Response to Supplementary Matters raised by DP&E

No.	Issue Raised	Proponent's Response
	Supplementary queries arising from DP&E community engagement – Email of 3 September 2018	
	Impacts of intensification of usage	
DPE37	<p>The proposal would result in the intensification of usage of the site in terms of the proposed number of events during each year. The increase in the frequency of the events would result in the usage of Moore Park as a car park more often. This is considered to be an adverse impact on the availability of parklands in the area for the purpose of community use. Further, the intensified use of Moore Park as a car park would result in further degradation of the park.</p> <p>In regards to these increased impacts what strategy can be developed to address the questions future intensification of usage on Moore Park?</p>	<p>There are currently no restrictions on the number of events that can be held annually at SFS, apart from concert events. Since its opening in 1988, the SFS has had at least 7 years with annual events greater than 50, with a peak number of 55 events occurring in 1992. As such there is no increase in intensity compared to existing operations based on

At 1pm, additional shadows (outside of Sydney Cricket and Sports Ground Trust Land) are created upon Fox Studios to the east of the site. The shadows fall upon an existing building and some existing soft landscaping.

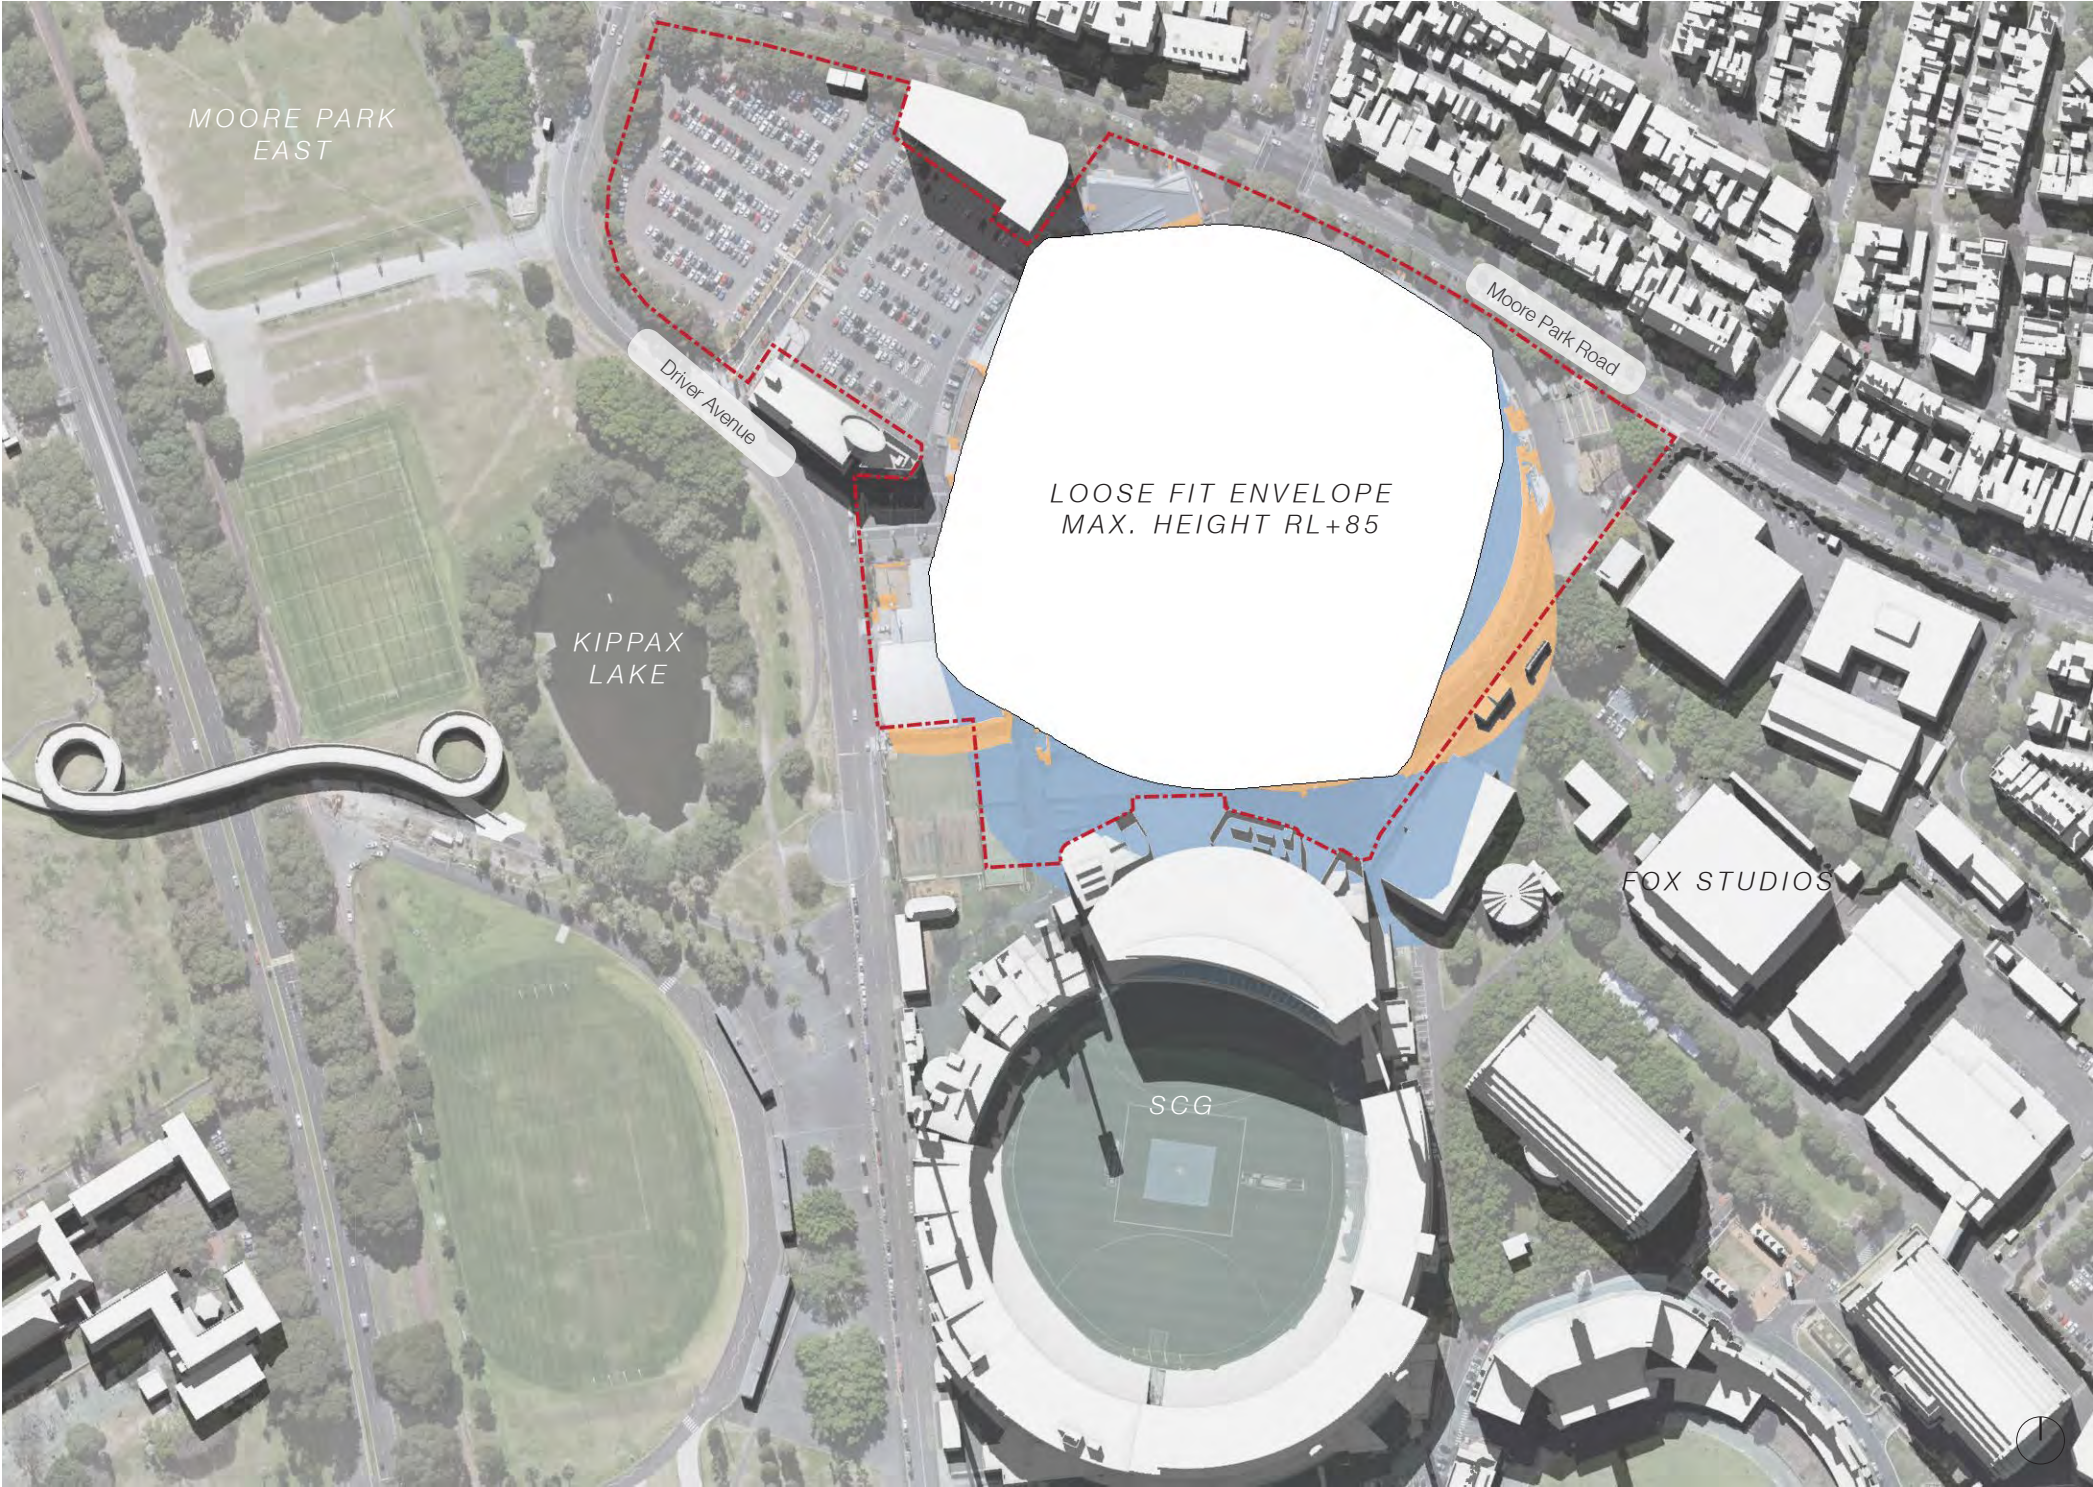
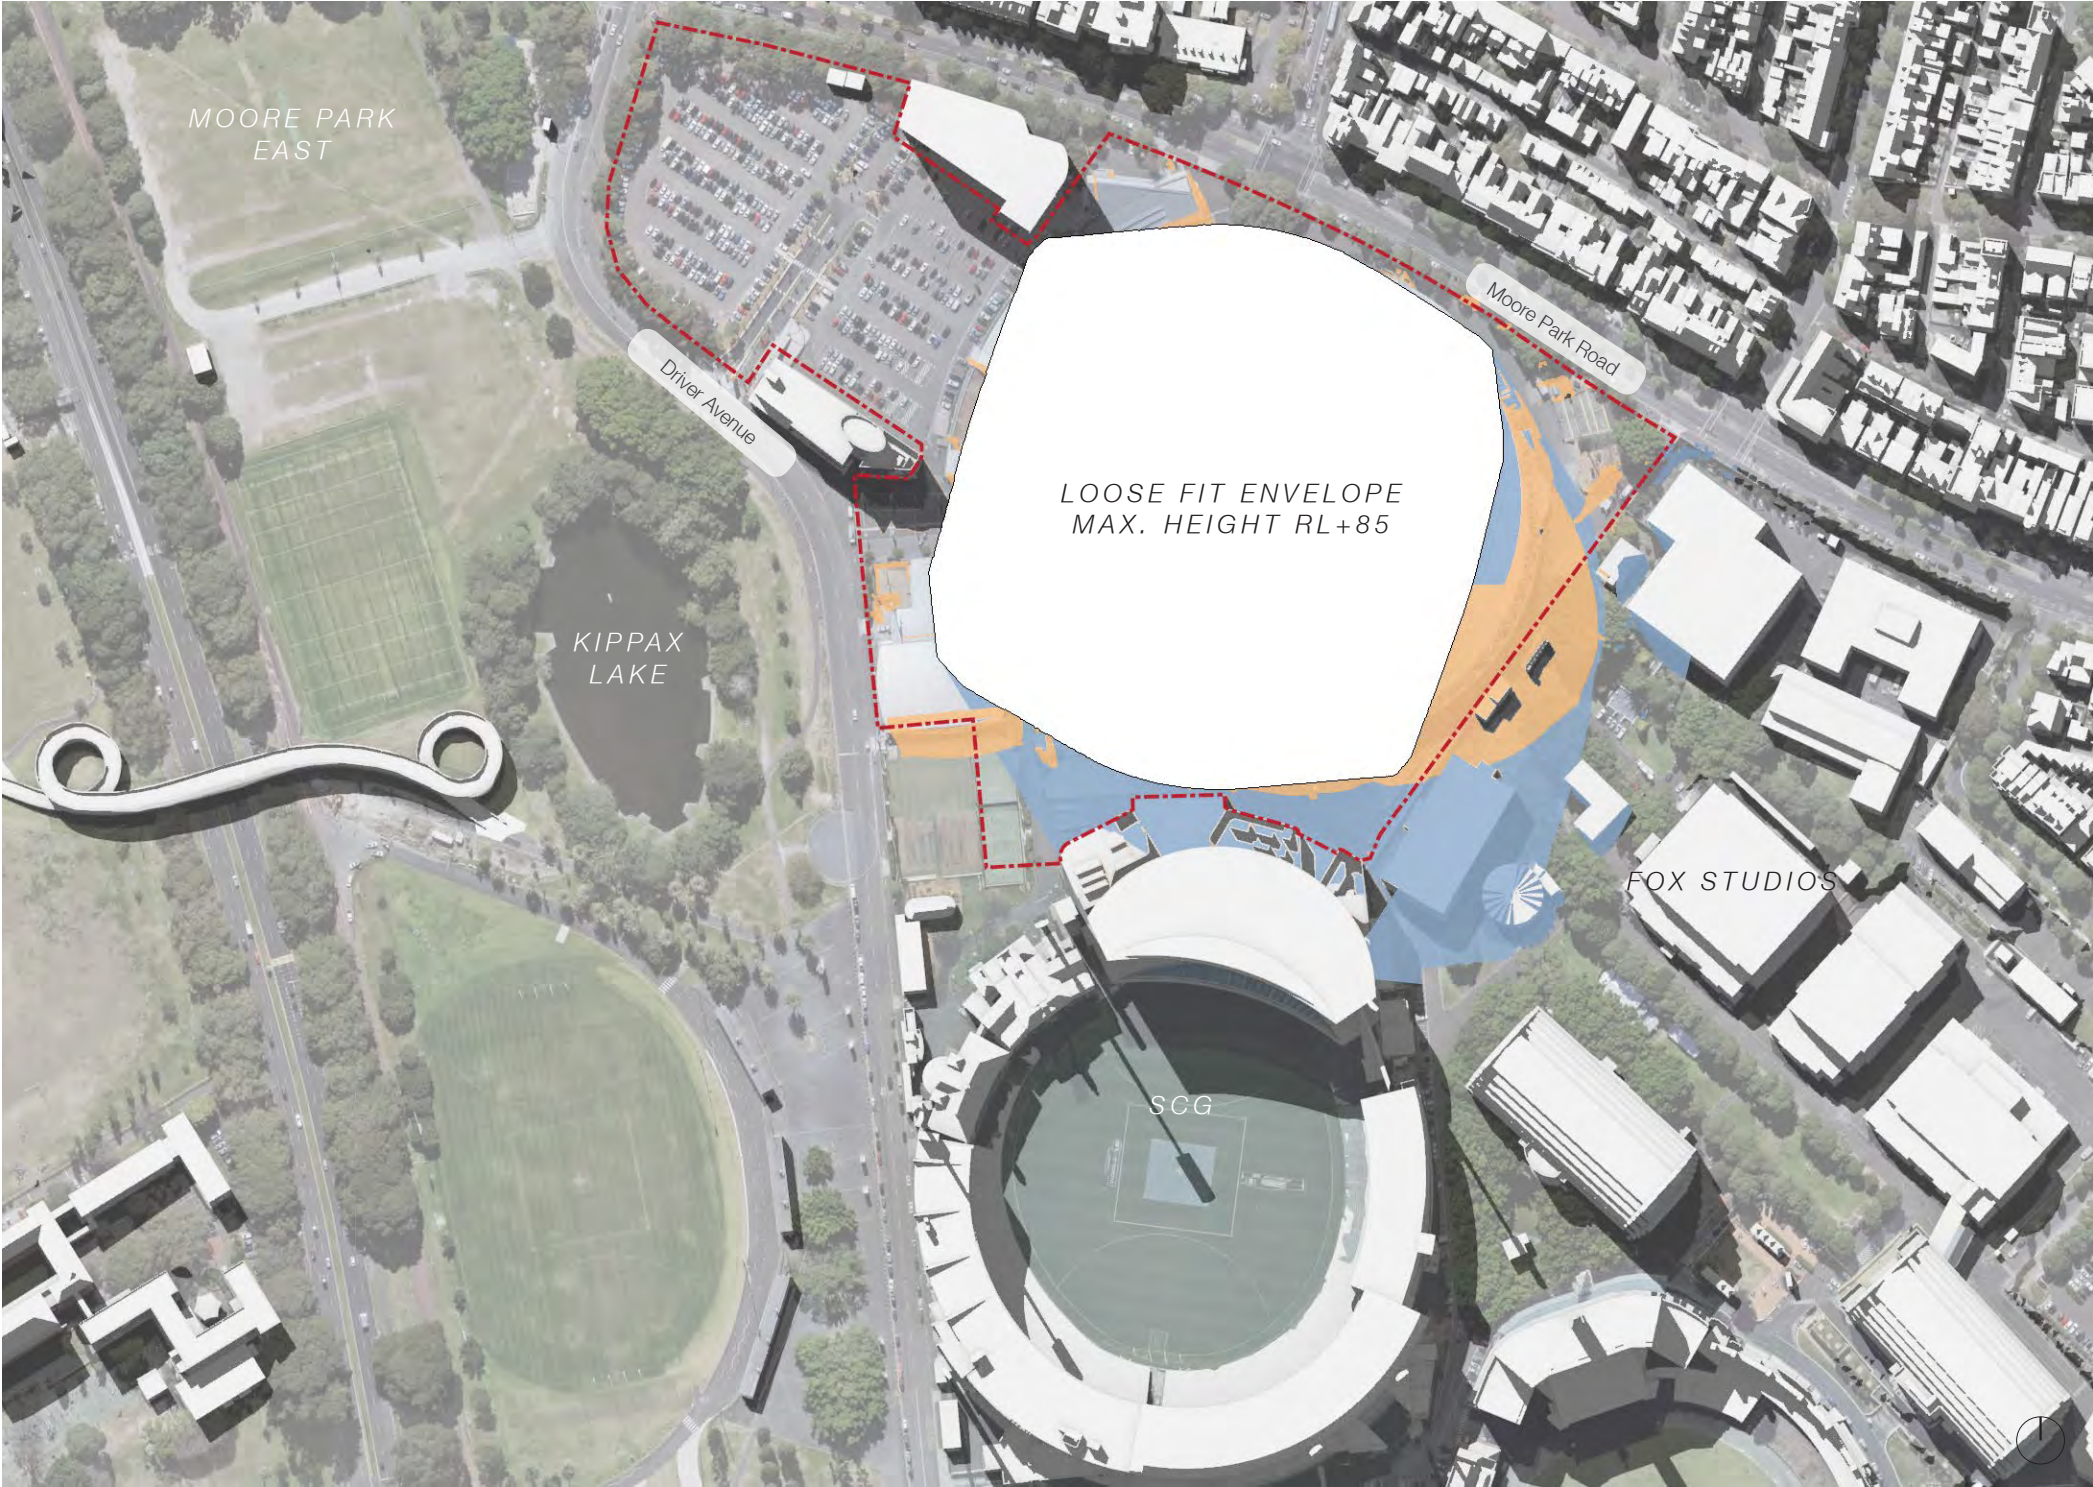
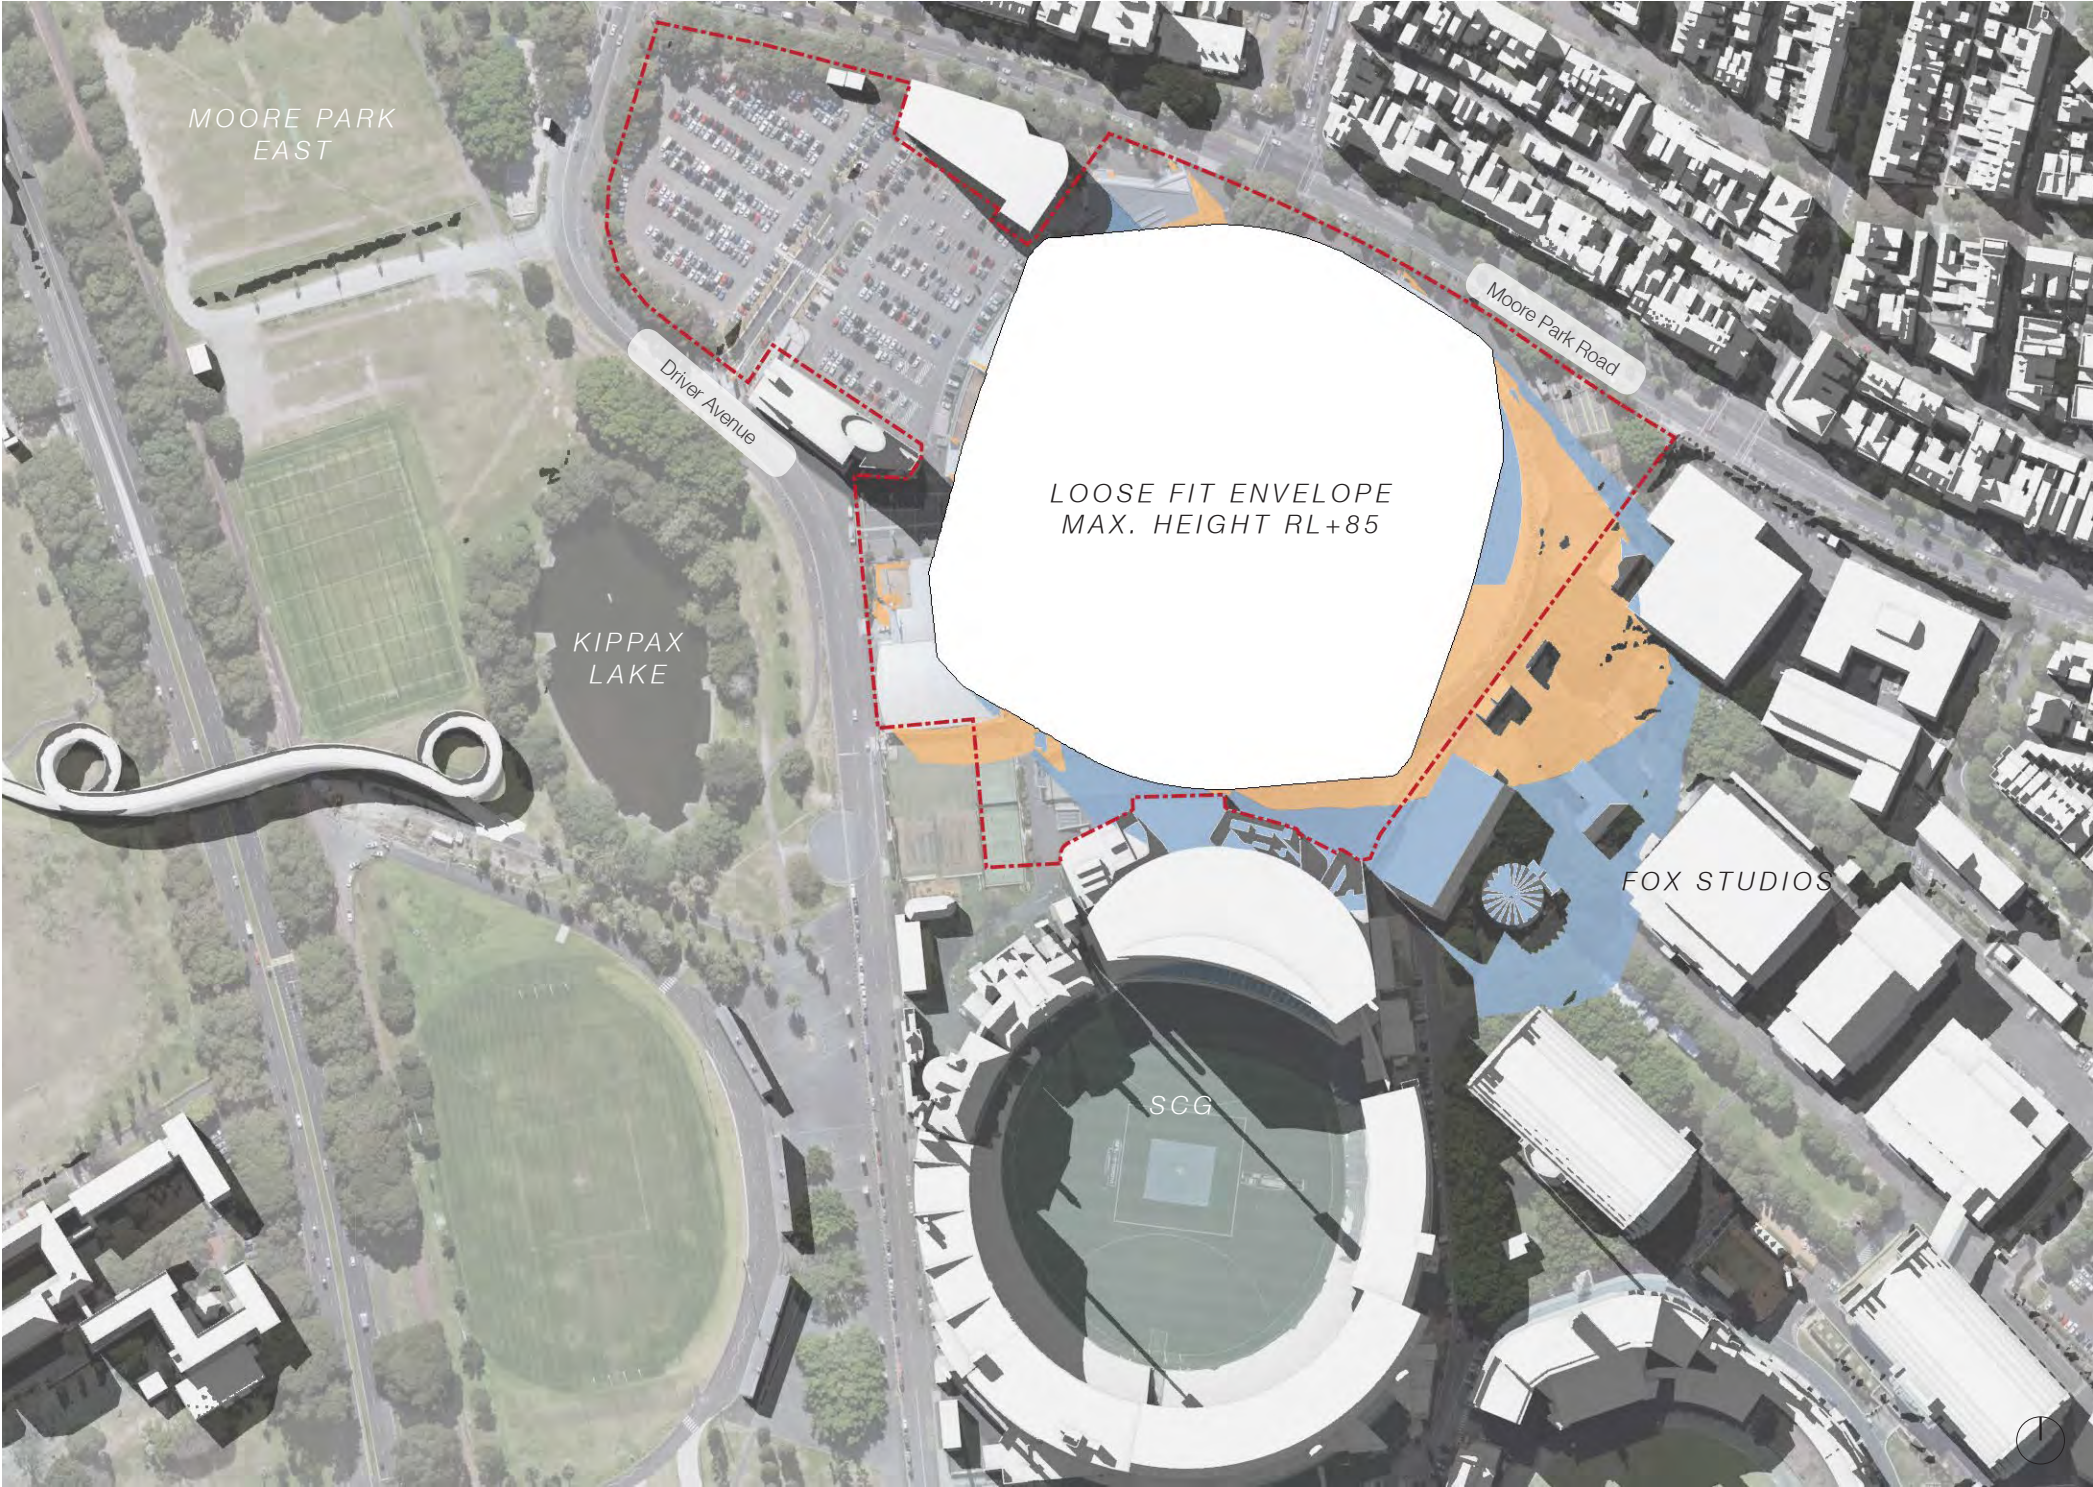
Shadow diagrams	
DPE45	The Shadow diagrams do not clearly show, describe or reflect the impact on Kippax Lake or Poate Road.	As illustrated in Attachment 4 of the Response to Submissions, there will not be any overshadowing of Kippax Lake or Poate Road between 9am and 3pm at mid-winter.
	Adverse Impacts of Demolition	
DPE46	The existing stadium may contain asbestos. In this regard, has Hazardous Materials Survey being conducted? If yes, then can the details be provided?	A Hazardous Materials Survey will be completed prior to the commandment of demolition works. Refer to Mitigation Measure S1-CG1 in the Final Mitigation Measures at Section 5.0 of the Response to Submissions.
	Community Consultative Committee (CCC)	
DPE47	The opportunity to create a CCC prior to the determination of this application is not constrained by the Department. Can INSW start this process?	The <i>Community Consultative Committee Guidelines</i> (DP&E, 2016) states that, if the Department decides a CCC is warranted, it will require the Proponent to establish the committee either through the SEARS (which is not the case for this project) or following approval through the conditions of approval for the project. Accordingly, the Applicant will establish a CCC at the time of approval if required by DP&E. It is understood that DP&E may require a CCC to be established prior to determination of the project. The Applicant has no objections to this.
